6 February 2018

Ms Iona Cameron  
Senior Planning Officer  
Social and Other Infrastructure Assessments  
Priority Projects  
Department of Planning and Environment

## **SSD 8334 -CONSTRUCTION OF A SCHOOL AT 120 -126 HEZLETT ROAD, KELLYVILLE**

Original Size **A1** Drawing No: **21-26108-KN-SD-CI-1011** Rev: **F**

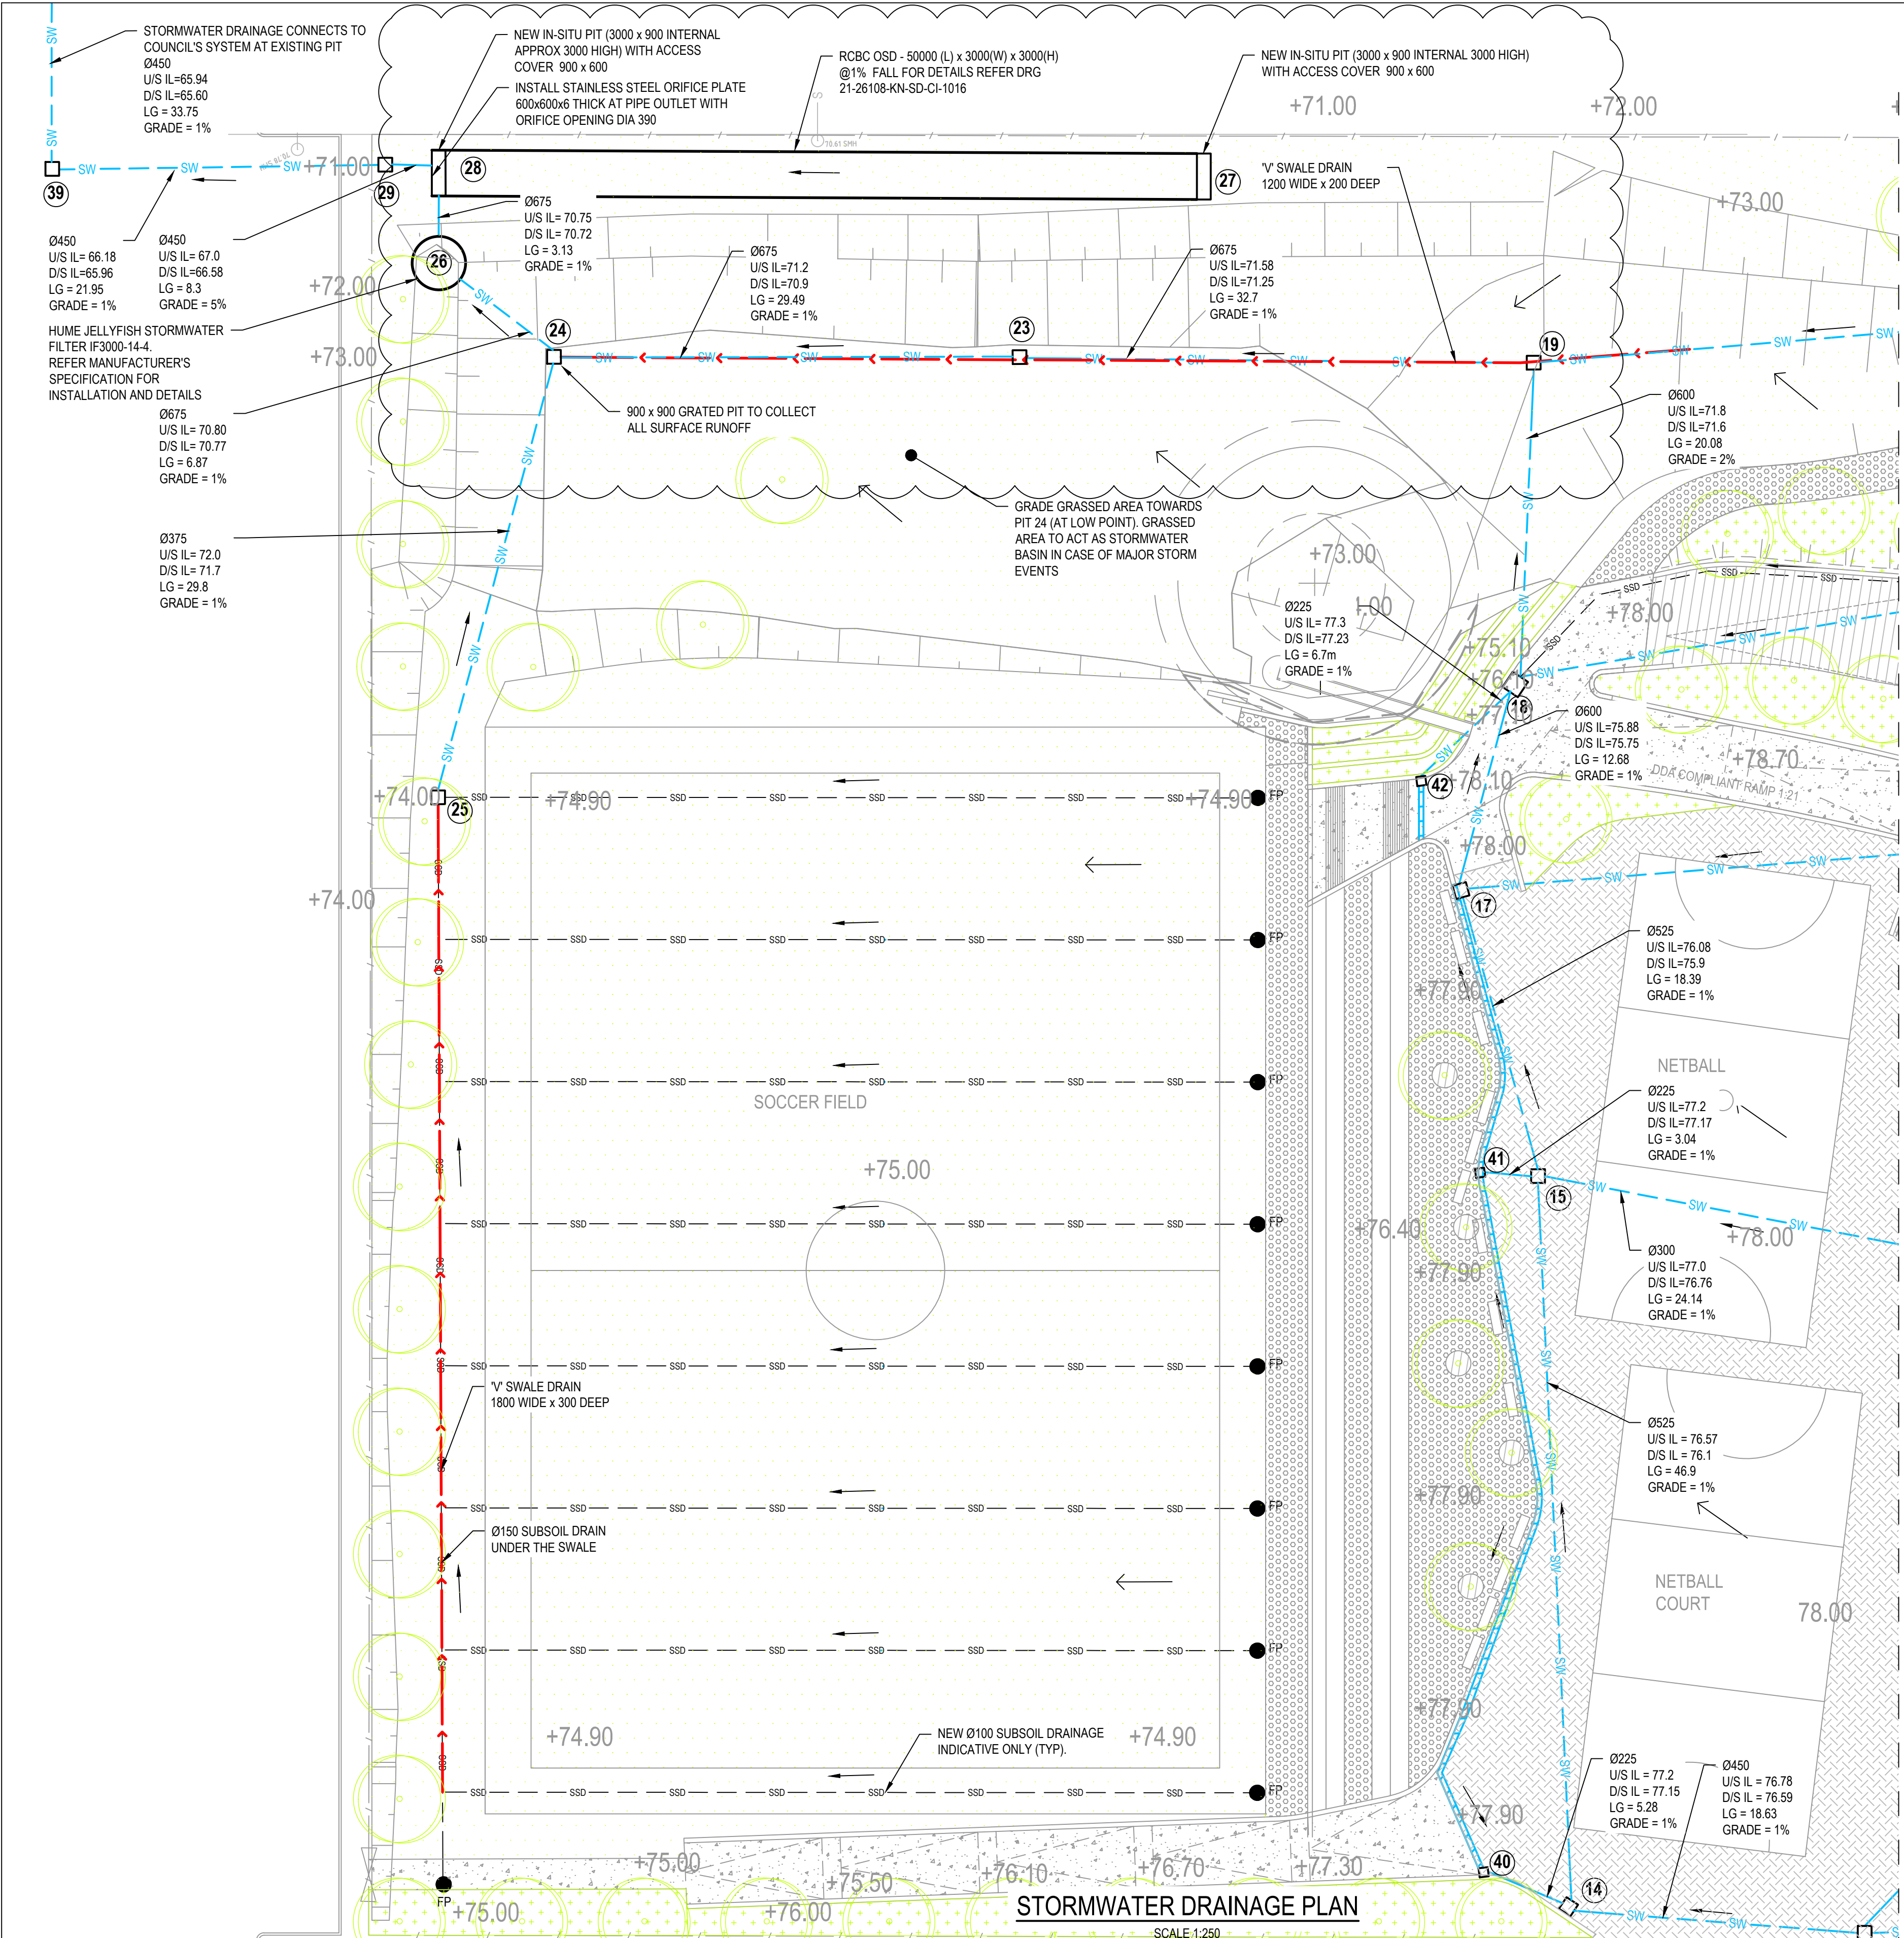
- The stormwater plan still does not show what roof areas are intended to drain to the rainwater reuse tank.

The existing pits and pipes need to be identified via survey and reflected on the plans to show that the pipe sizes and levels included on the design will actually work.

The updated stormwater plan that accompanies this submission indicates the area of the roof that will drain to the rainwater re-use tank.

An existing pit was identified along Hipwell Road and the proposed stormwater is to connect to that pit. Refer to the Note on Drawing No. 21-26108-KN-SD-CI-1010. Given this it is considered that the submitted plans demonstrate that the design will appropriately convey stormwater from the site.

STORMWATER DRAINAGE PLAN

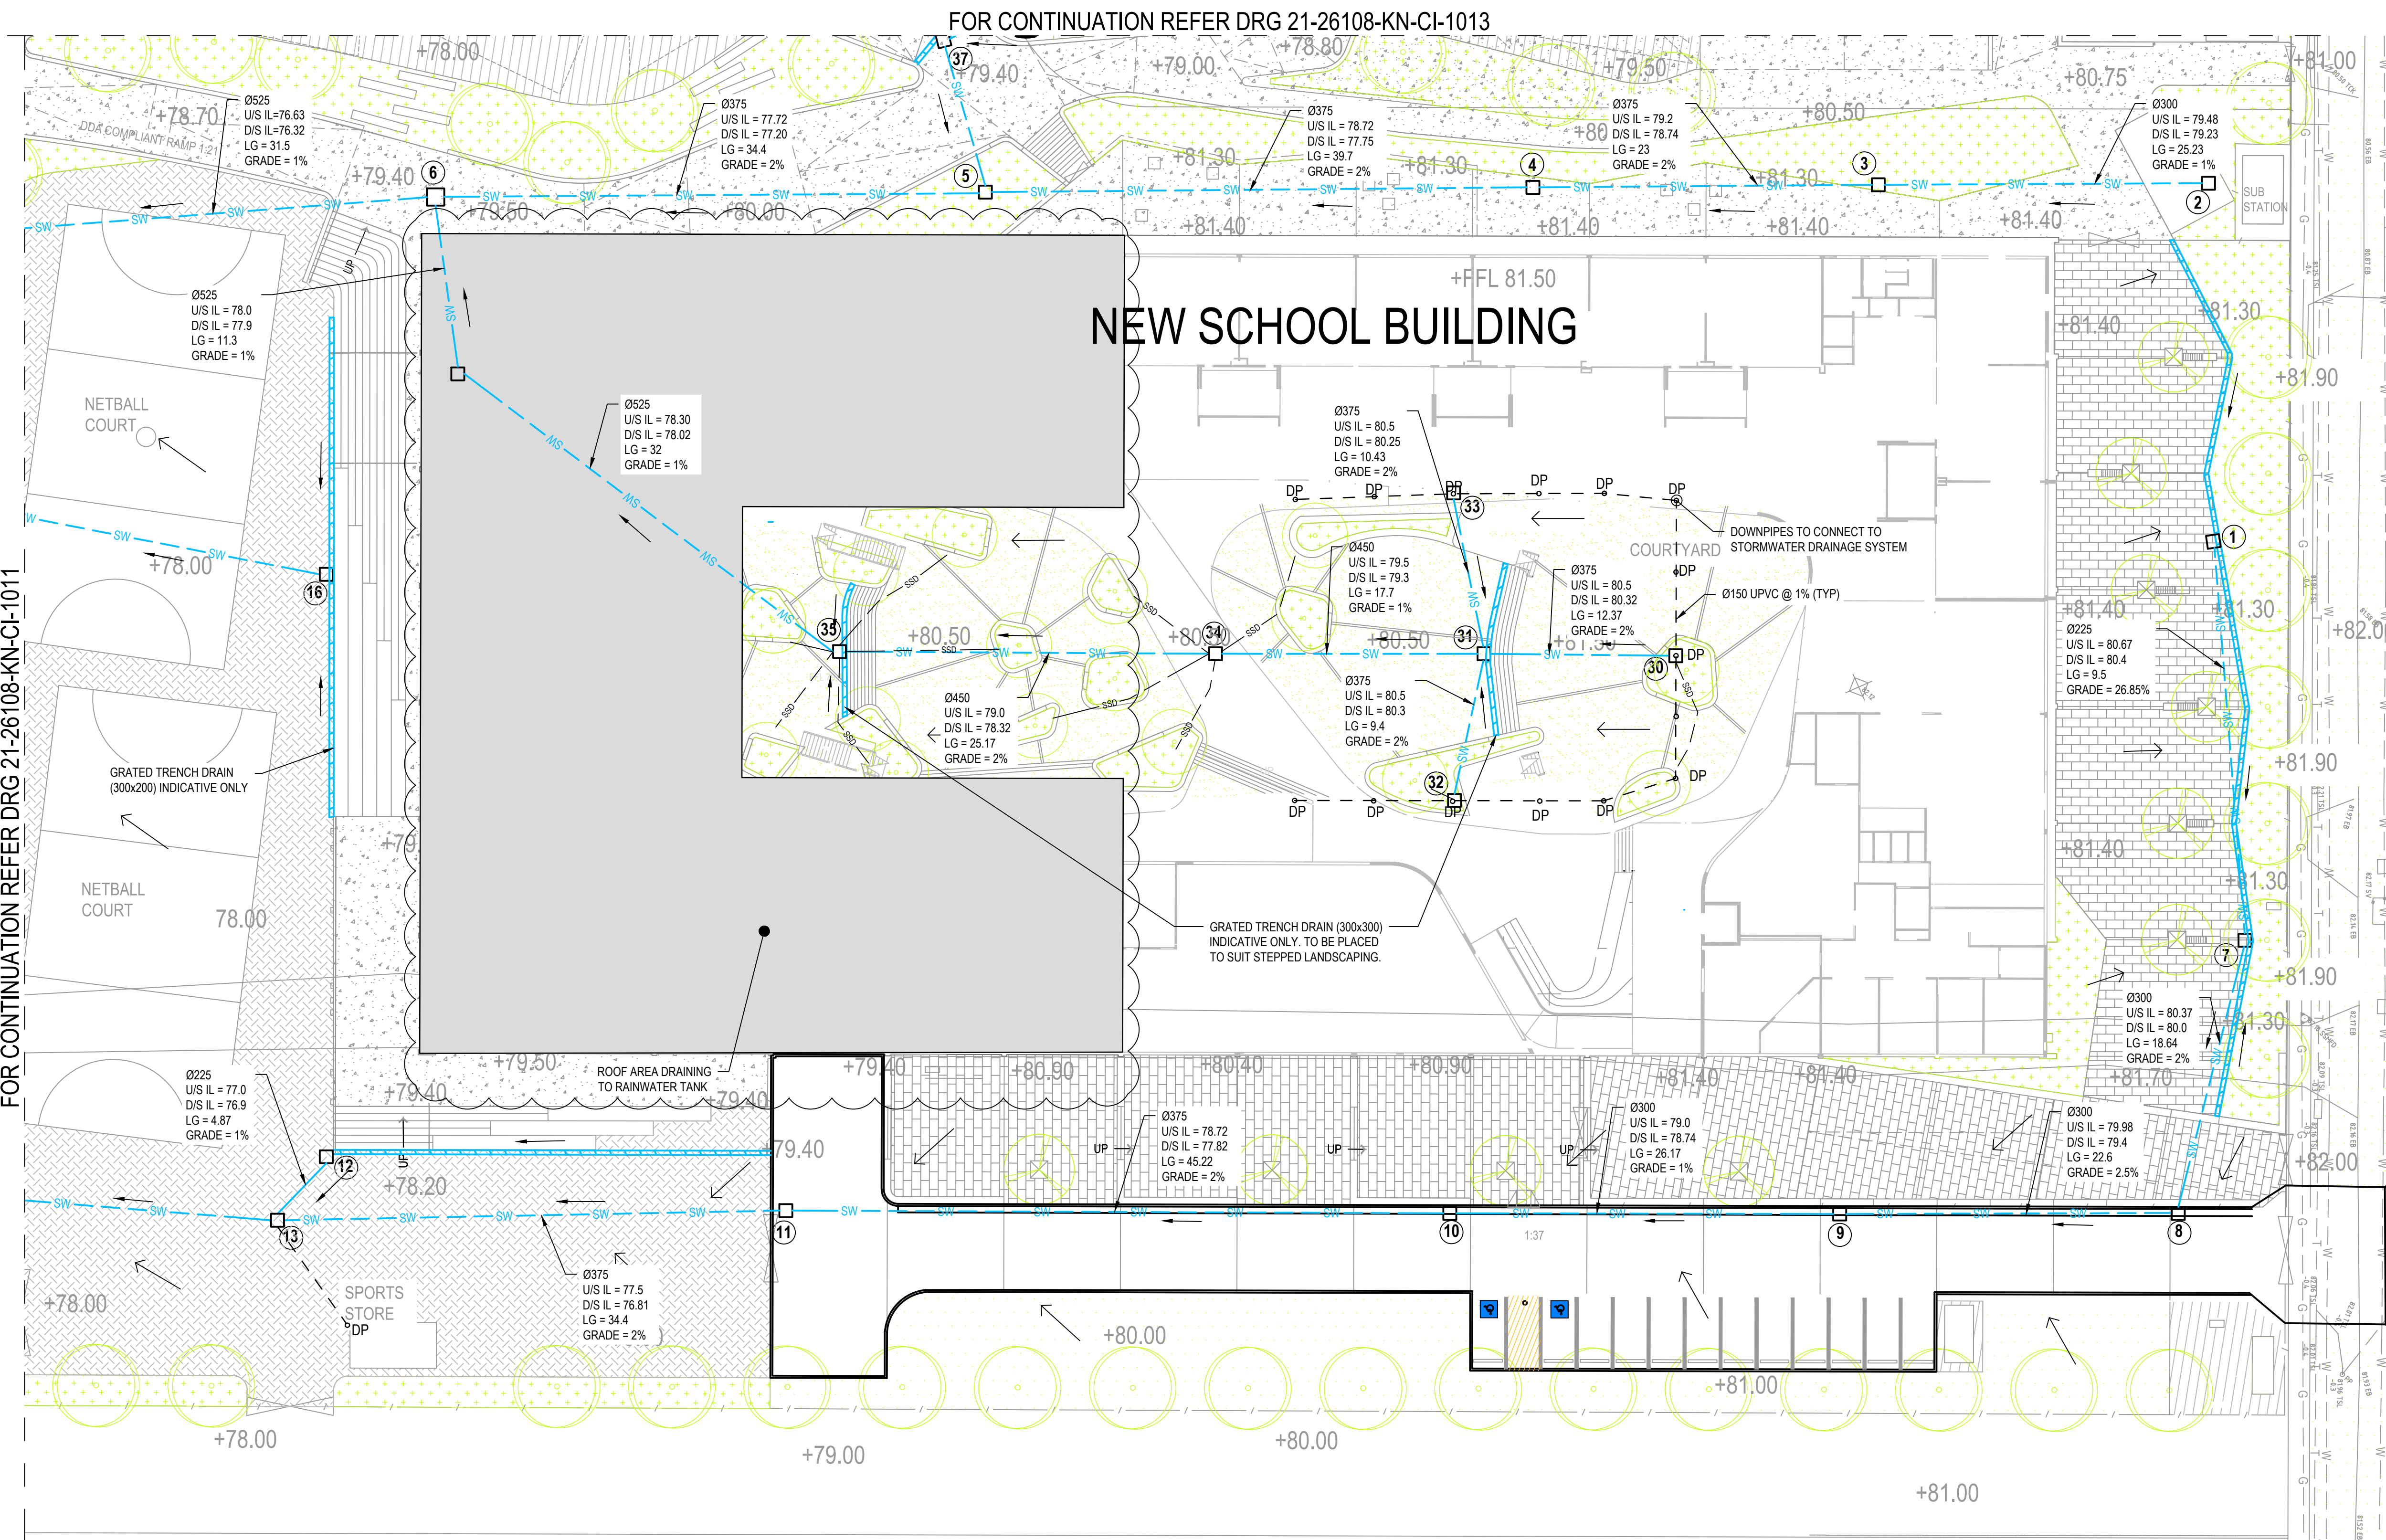
- The stormwater report refers to 900 cubic metres of OSD storage however the stormwater plan shows only 634.5 cubic metres of storage.

- The stormwater report refers to a 12.5 cubic metre rainwater tank however the stormwater plan refers to a 22.5 cubic metre rainwater tank.

As per the UPRCT On-site Stormwater Detention Handbook, above ground storage is to be used for stormwater detention where possible. Therefore, the In-Ground Tank provides 634.5m<sup>3</sup> of stormwater storage, which is enough for the 20 year storm event, with the additional 265.5 m<sup>3</sup> of storage provided in the aboveground basin (grassed area) for the case of a 100 Year storm event.

The Plans are correct, and the Rainwater Tank is to be 22.5m<sup>3</sup>. The report has been updated with the correct figure.
